**KIRKLEES METROPOLITAN COUNCIL  
INVESTMENT & REGENERATION SERVICE**

Reference No:	<b>2023/44/91673/E</b>
Site Address:	Low Farm, Wakefield Road, Grange Moor, Huddersfield, WF4 4BB
Description:	Discharge condition 16 (Coal Mining Risk Assessment) on previous permission 2021/93644 for erection and operation of grid-connected solar photovoltaic farm to supply up to 49.9MW, with ancillary infrastructure and landscaping and biodiversity enhancements
Recommending Officer:	Nick Hirst

**DECISION – Discharge of Conditions-Approved**

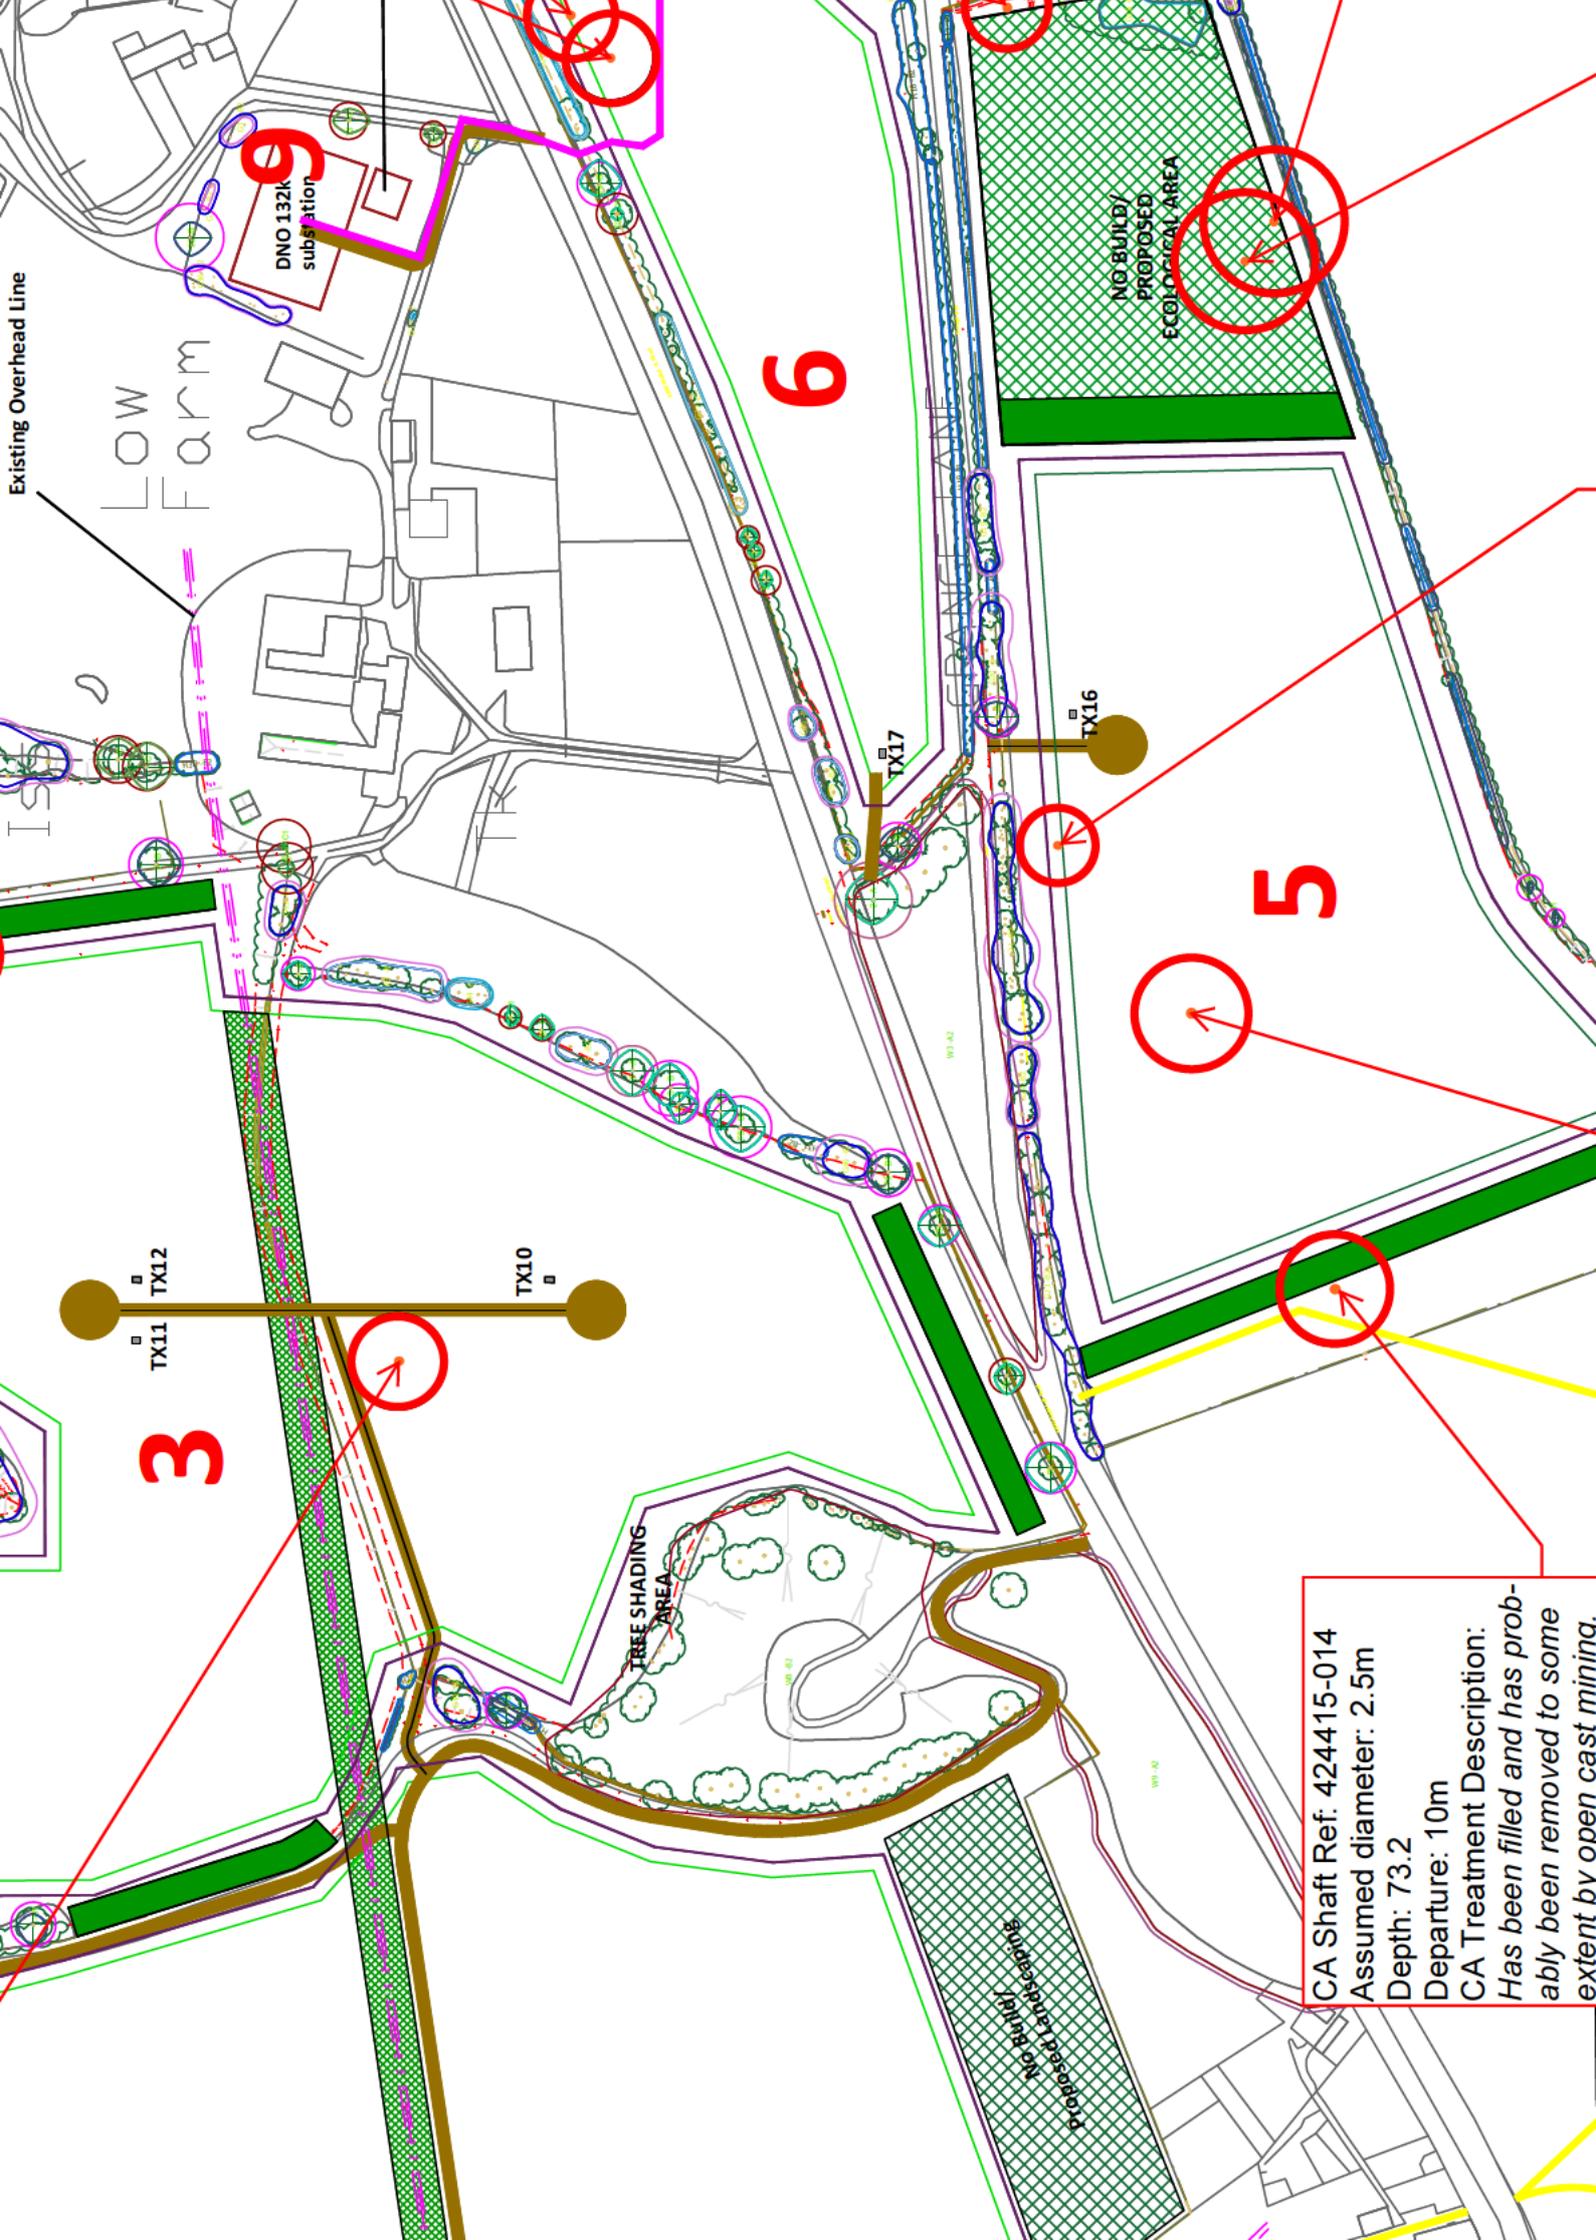
*Solar arrays are now exempt from requiring coal mining risk assessments, as the applicant's agent correctly acknowledges in their supporting letter dated 2 June 2023. On the basis that the content of the letter confirms that cognisance will be afforded to positioning the arrays and associated infrastructure away from the mine entries and their zones of influence, the Coal Authority would raise no objections should the LPA be minded to discharge Condition 16.*

Officers support the Coal Authorities assessment. In summary the investigations have concluded no remediation is necessary, due to infrastructure (i.e. access roads, transformer units and substations) being

positioned outside of coal works zones of influence. Solar panels within the ZOIs are not opposed by the CA in accordance with their guidance.

Accordingly, officer recommend that condition 16 be discharged. Given the outcome, there are no ongoing requirements and the condition may be discharged in full.
